ROI PROPERTY GROUP
 NORWOOD BIBLE CHURCH
 SITE DEVELOPMENT PLAN

PPR-23-046

V1_Site Development Plan Comments.pdf Markup Summary

ROI PROPERTY GROUP  
 NORWOOD BIBLE CHURCH  
 SITE DEVELOPMENT PLAN

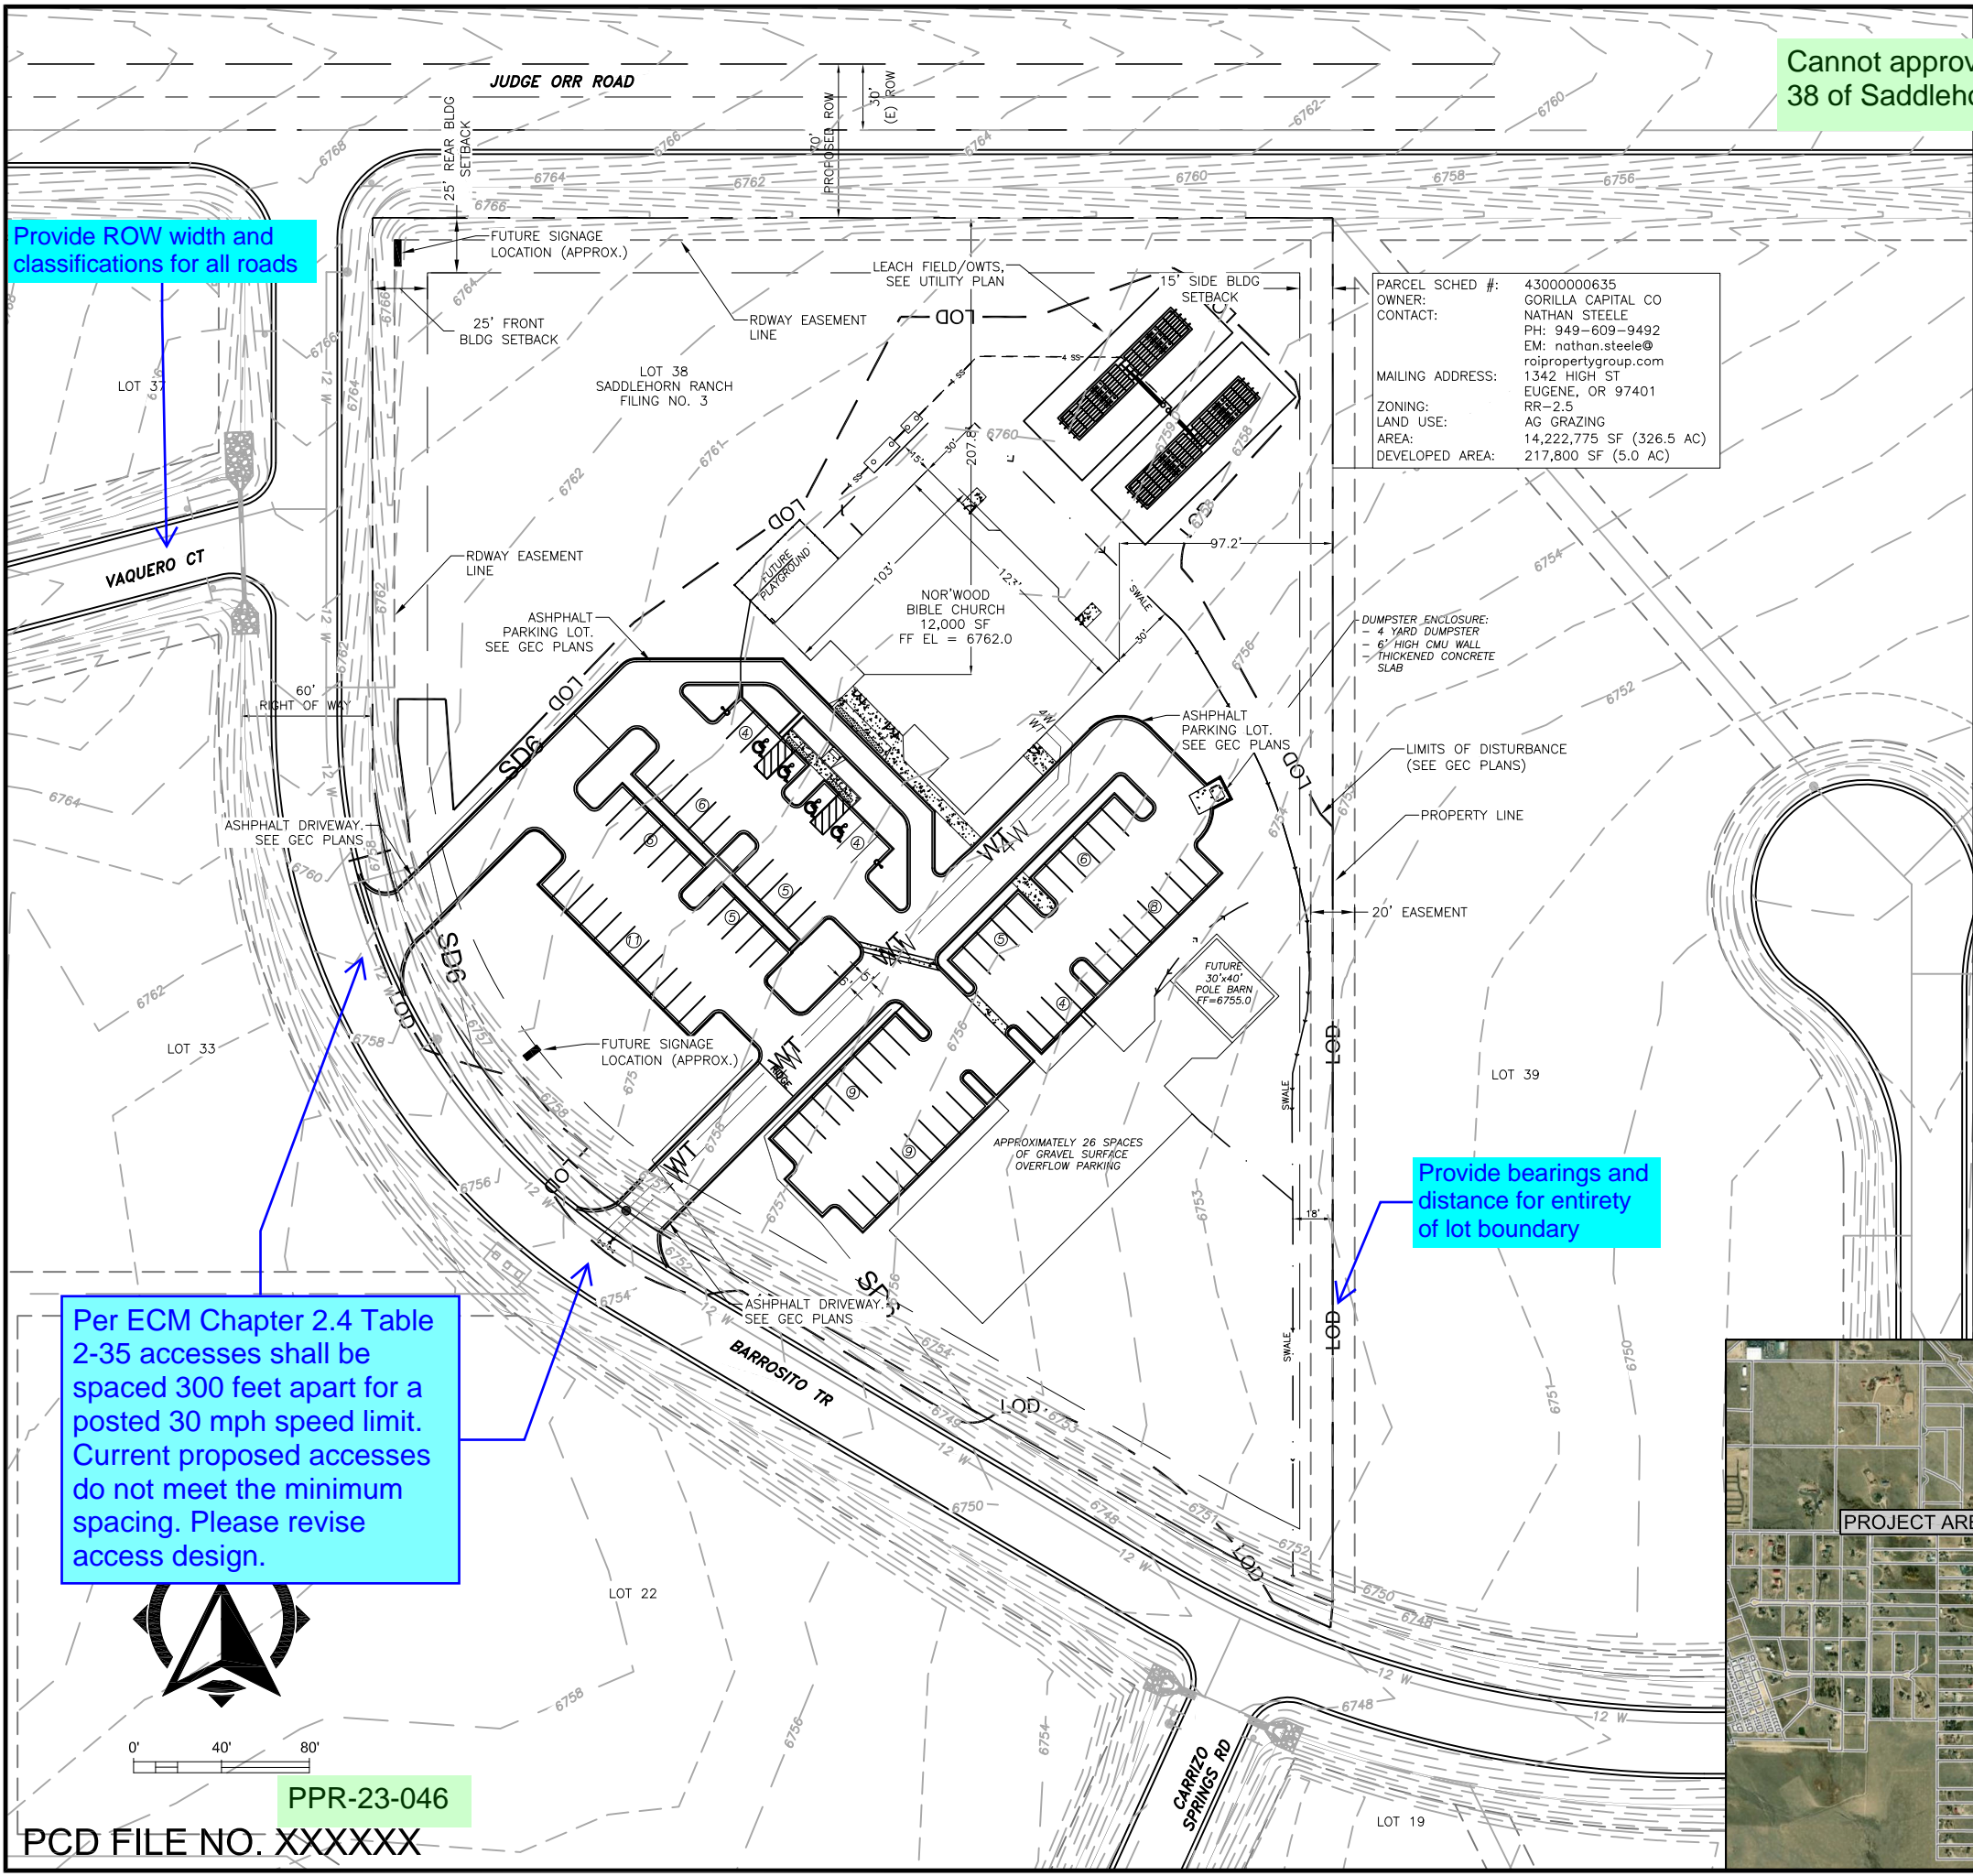
Per ECM Chapter 2.4 Table 2-35 accesses shall be spaced 300 feet apart for a posted 30 mph speed limit. Current proposed accesses do not meet the minimum spacing. Please revise access design.

Provide ROW width and classifications for all roads

Provide bearings and distance for entirety of lot boundary
